TfNSW reference: STH25/00160/002

Your reference: SSD-76440958

SSD-76440958 – MIXED USE DEVELOPMENT WITH INFILL AFFORDABLE HOUSING – PUBLIC AUTHORITY CONSULTATION – 221 TO 291 CROWN STREET, 216 TO 238 KEIRA STREET AND 86 TO 90 BURELLI STREET, WOLLONGONG

Attachment 1

Project Title: 221-291 Crown Street, 216-238 Keira Street, 86-90 Burelli Street, Wollongong NSW 2520. Drawing Title: GENERAL ARRANGEMENT PLAN SHEET 02. Drawing No: S02-C302. Date: 24.04.25. Issue: 01. Project Manager: [Name]. Design Engineer: [Name]. Checker: [Name]. Approver: [Name].

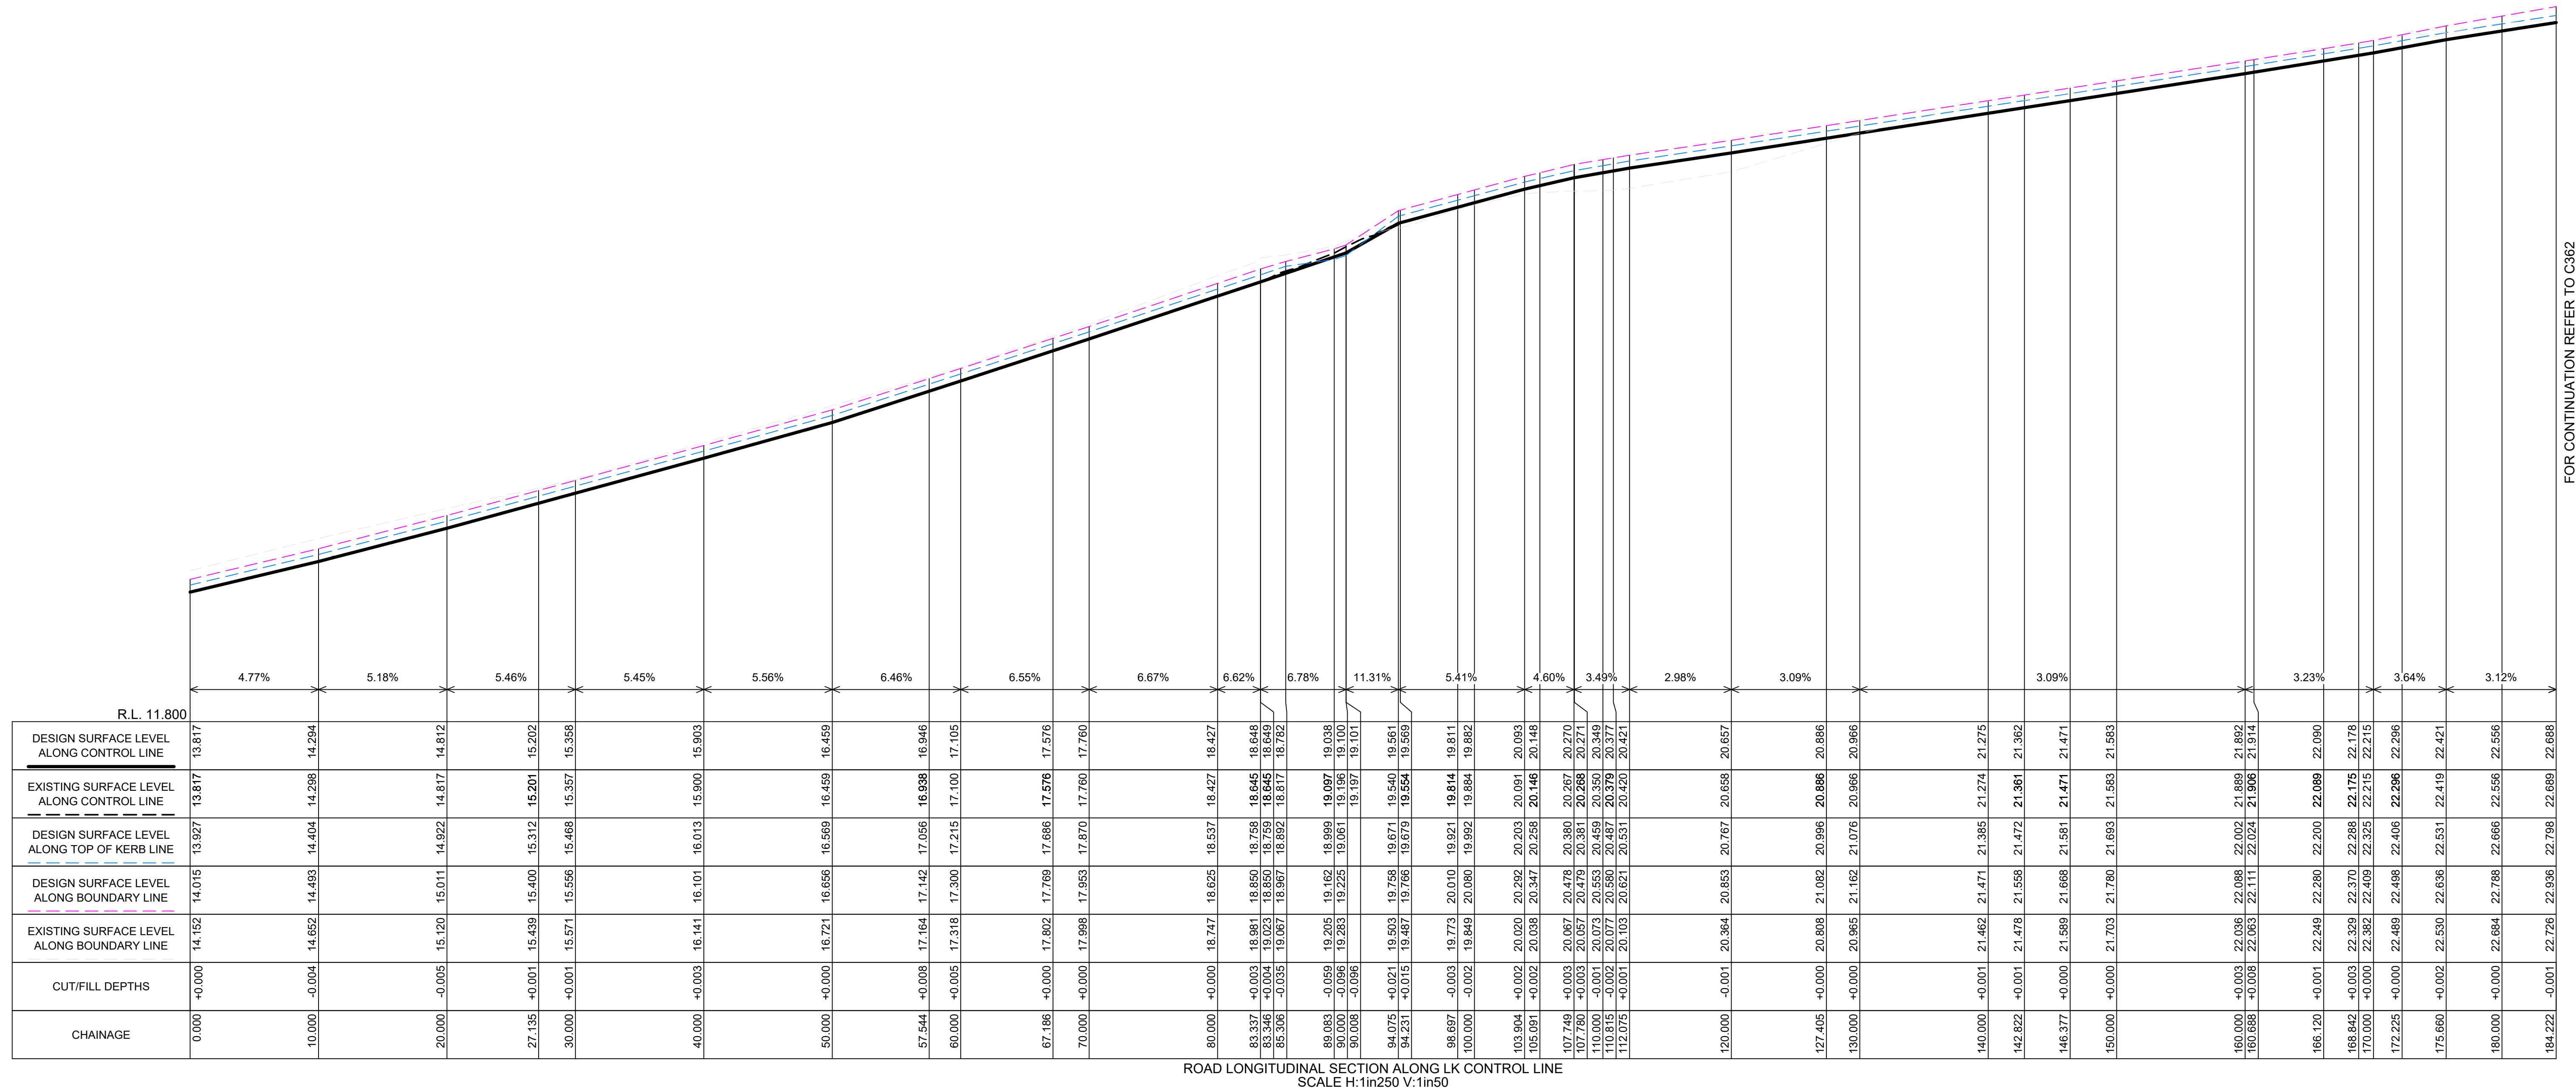
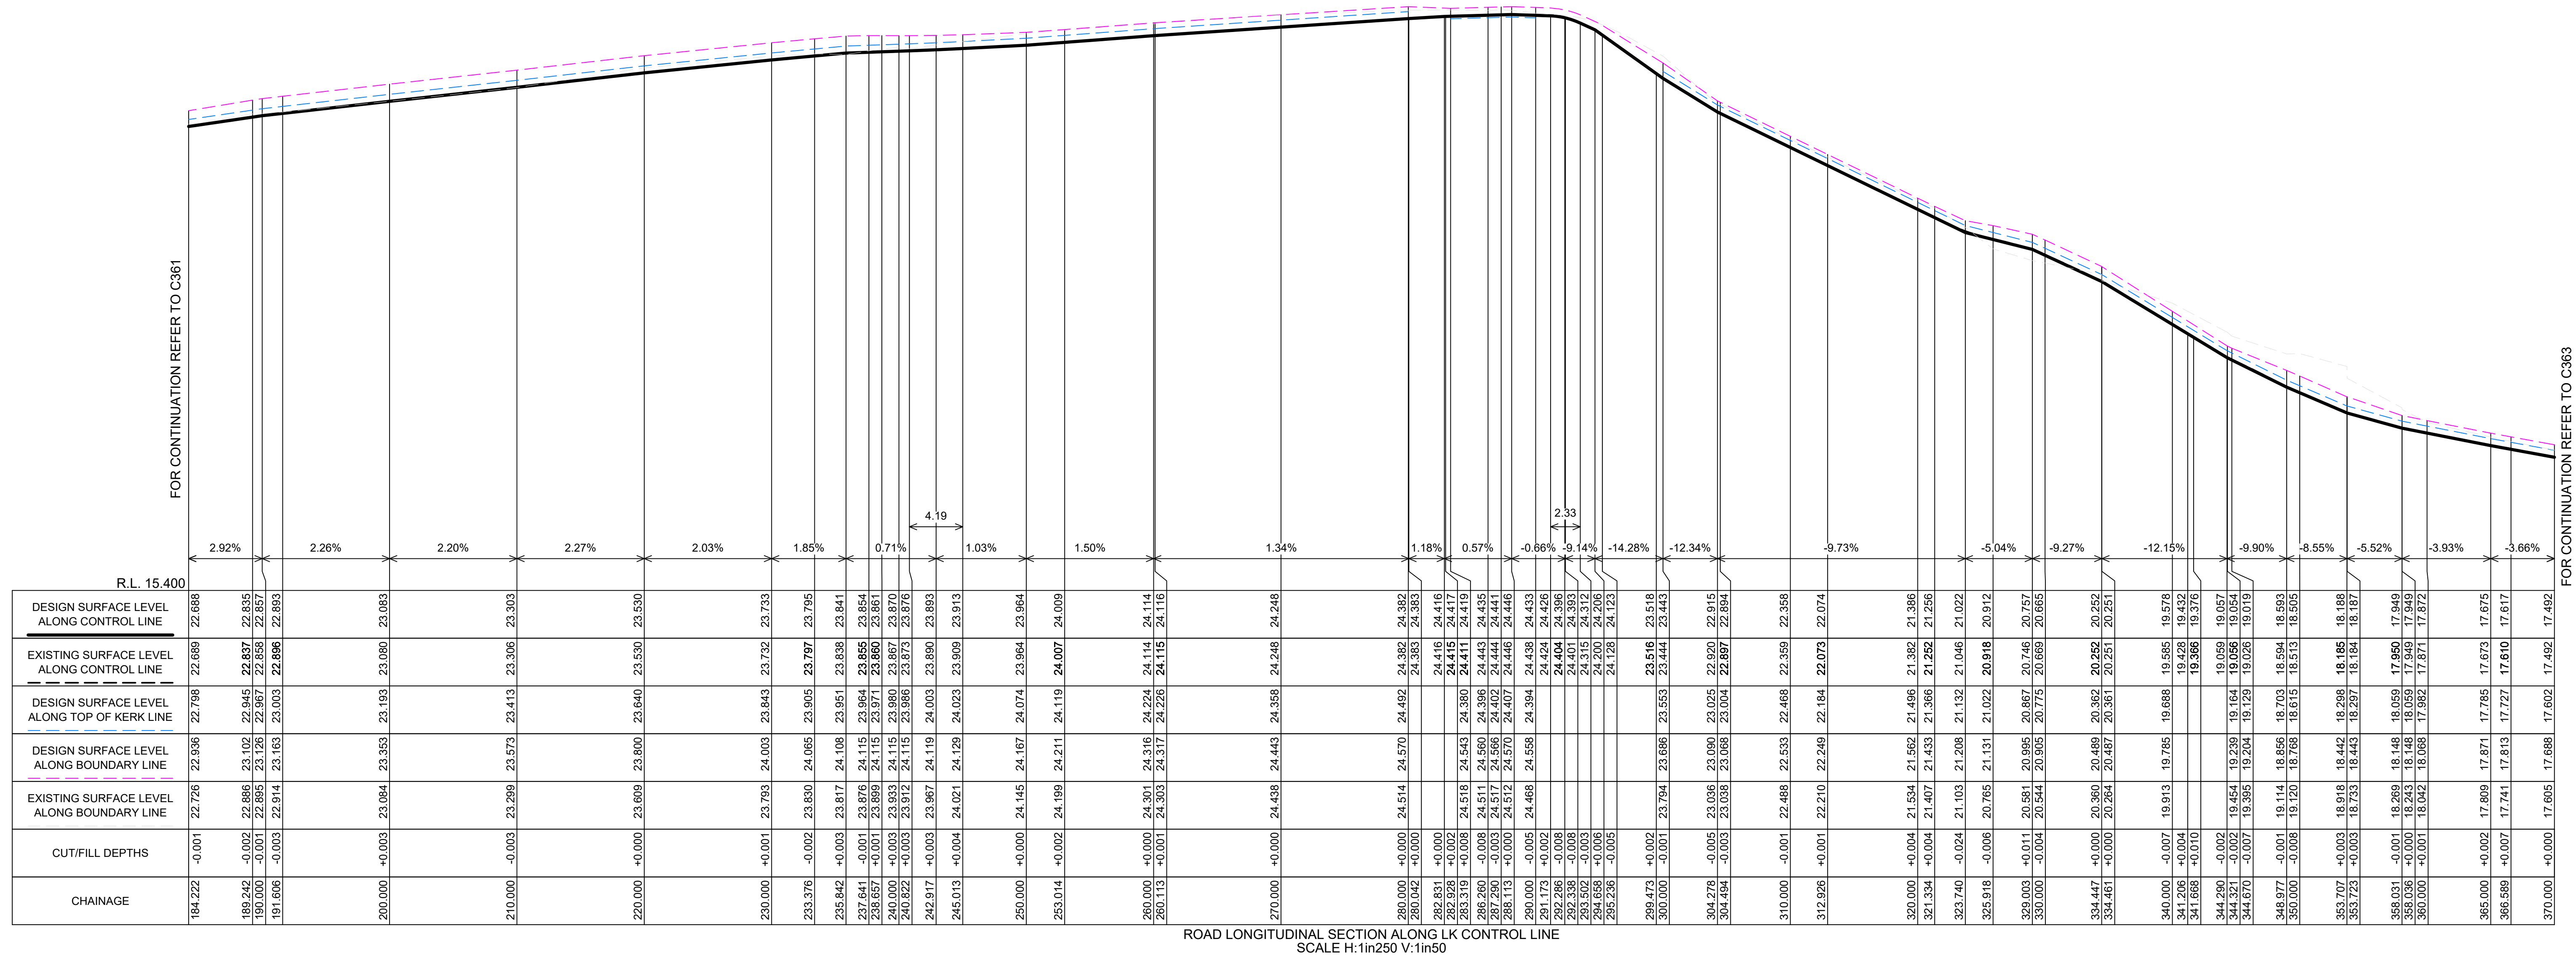
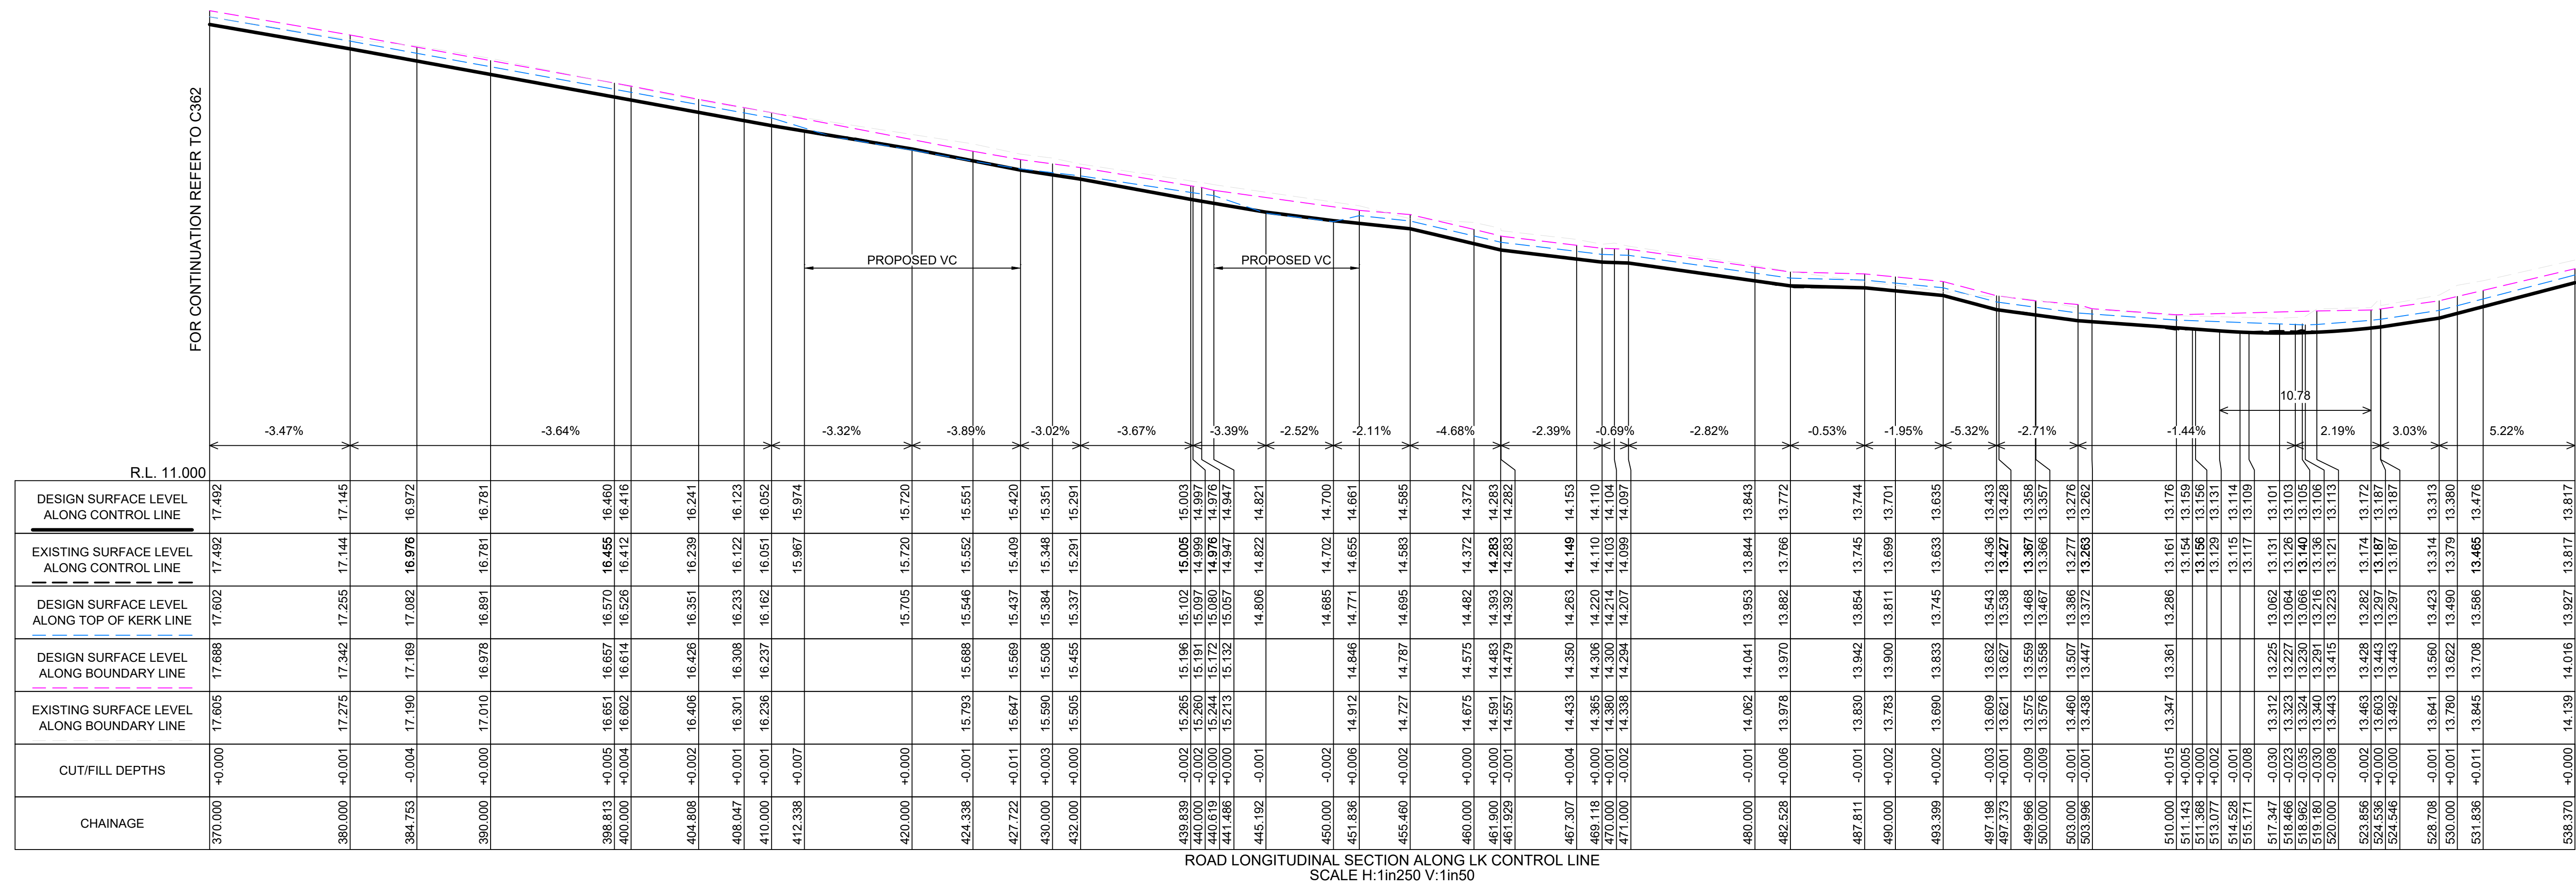
- i) The plan submitted (Public Domain Concept Design, prepared by S&G Consultants Pty Ltd with reference Project No. 20240207, Dwg No. SC02-C301, Revision A Dated 24.04.25) includes a 20m taper. The taper represents the draw out length, and this can be reduced to 6m provided the angle of the kerb (between the widened kerb line and the existing kerb line) is appropriate to allow a bus to draw out. This will need to be supported with a swept path analysis for a 12.5m bus.

- ii) The above referenced Public Domain Concept Design plan includes a 43.5m bus zone. Excluding the draw out length described above, the bus zone needs to be a minimum 49m in length.

- b) Insufficient information has been provided to enable TfNSW to support the kerb widening and the associated reduction in travel lanes on Crown Street, as well as a pedestrian crossing that is proposed within the Crown Street kerb widening (refer to S&G Consultants Pty Ltd Public Domain Concept Plans). To enable TfNSW to undertake an assessment, plans are required that:

TfNSW also notes inconsistencies between the Detailed Landscape Plan prepared by Land+Form (Drawing No. LD-DA101, Revision 1, dated 15.09.2025) and the Public Domain Concept Design prepared by S&G Consultants Pty Ltd. For example, the pedestrian crossing shown in the concept design is not reflected in the landscape plan. Furthermore, both the Environmental Impact Statement and the Traffic Impact Assessment are silent on the proposed outdoor dining along the Crown Street frontage.

- a) The length of the bus zone that is a minimum of 55m to provide sufficient length for three buses to utilise the bus stop at the same time, including any of the three buses to exit upon completion of boarding. This 55m includes a minimum 6m draw out length at the start of the bus zone (the eastern end). Refer to Section 3.7 of the *State Transit Bus Infrastructure Guide*, Issue 2. In achieving the 55m, it should be noted:
